From: Laura Gibbons
Sent: 07 May 2019 09:27
To: 'John Hall'
Cc: Andrew Wood; David Moore - Consulting [REDACTED]
Subject: RE: F/30/18/PL - Drainage comments

Thank you for your comments concerning our application to erect multispan polythene tunnels at Wicks Farm, Ford – F/30/18/PL.

SECTION B-B - POND OVERFLOW DRAINAGE PIPE
(SCALE 1:50)

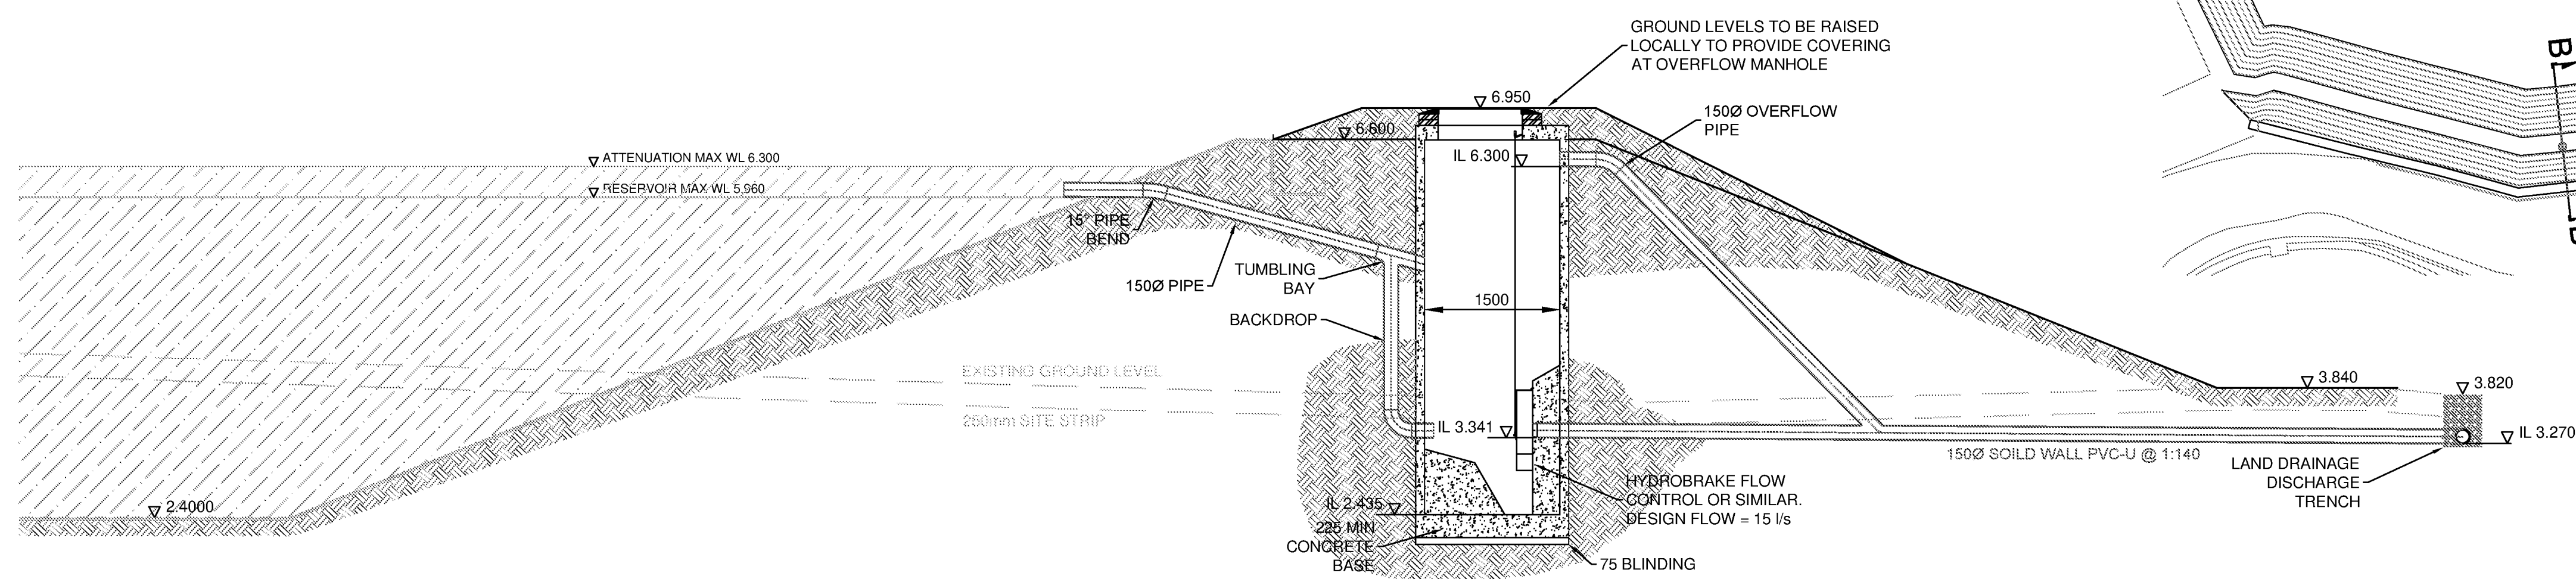
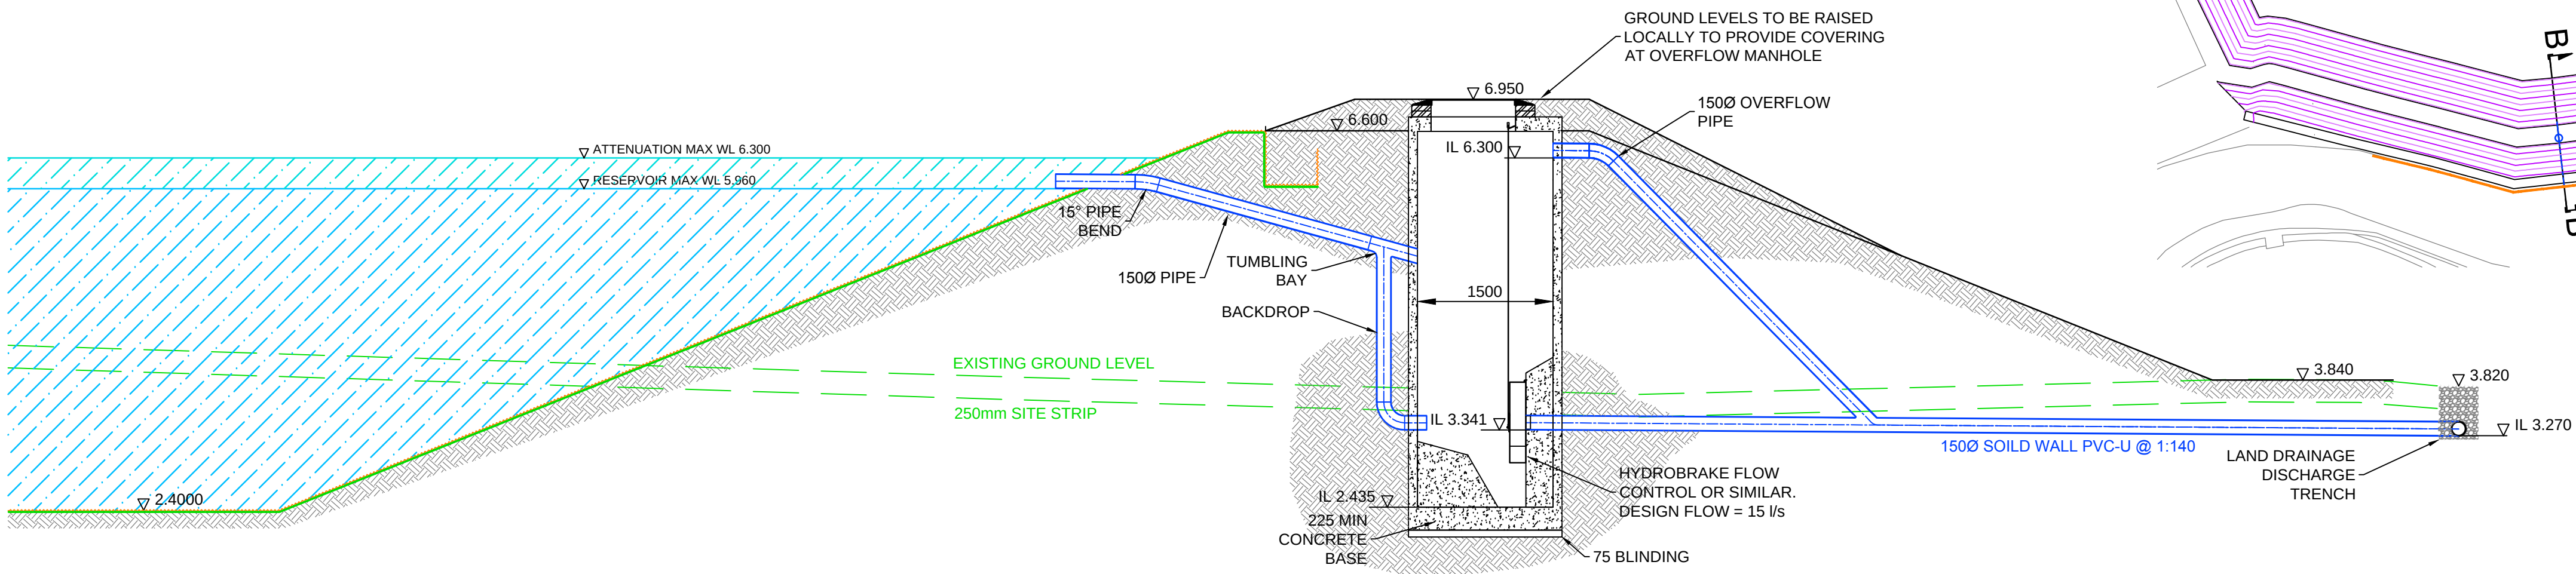
My main concern is the location of this proposed overflow. I.e. which watercourse are you discharging to and where? Without this information the fundamental concepts cannot be agreed.

Can you please update the surface water drainage proposals to clearly show this proposed overflow to the ditch system?

The Access & Design Statement explains and the technical drawing shows that all the rain water falling on the multispan polythene tunnels will drain North to the new reservoir planned for the lowest part of the field. An overflow system will be designed to take surplus water to the existing local ditch system and onward directly to the River Arun.
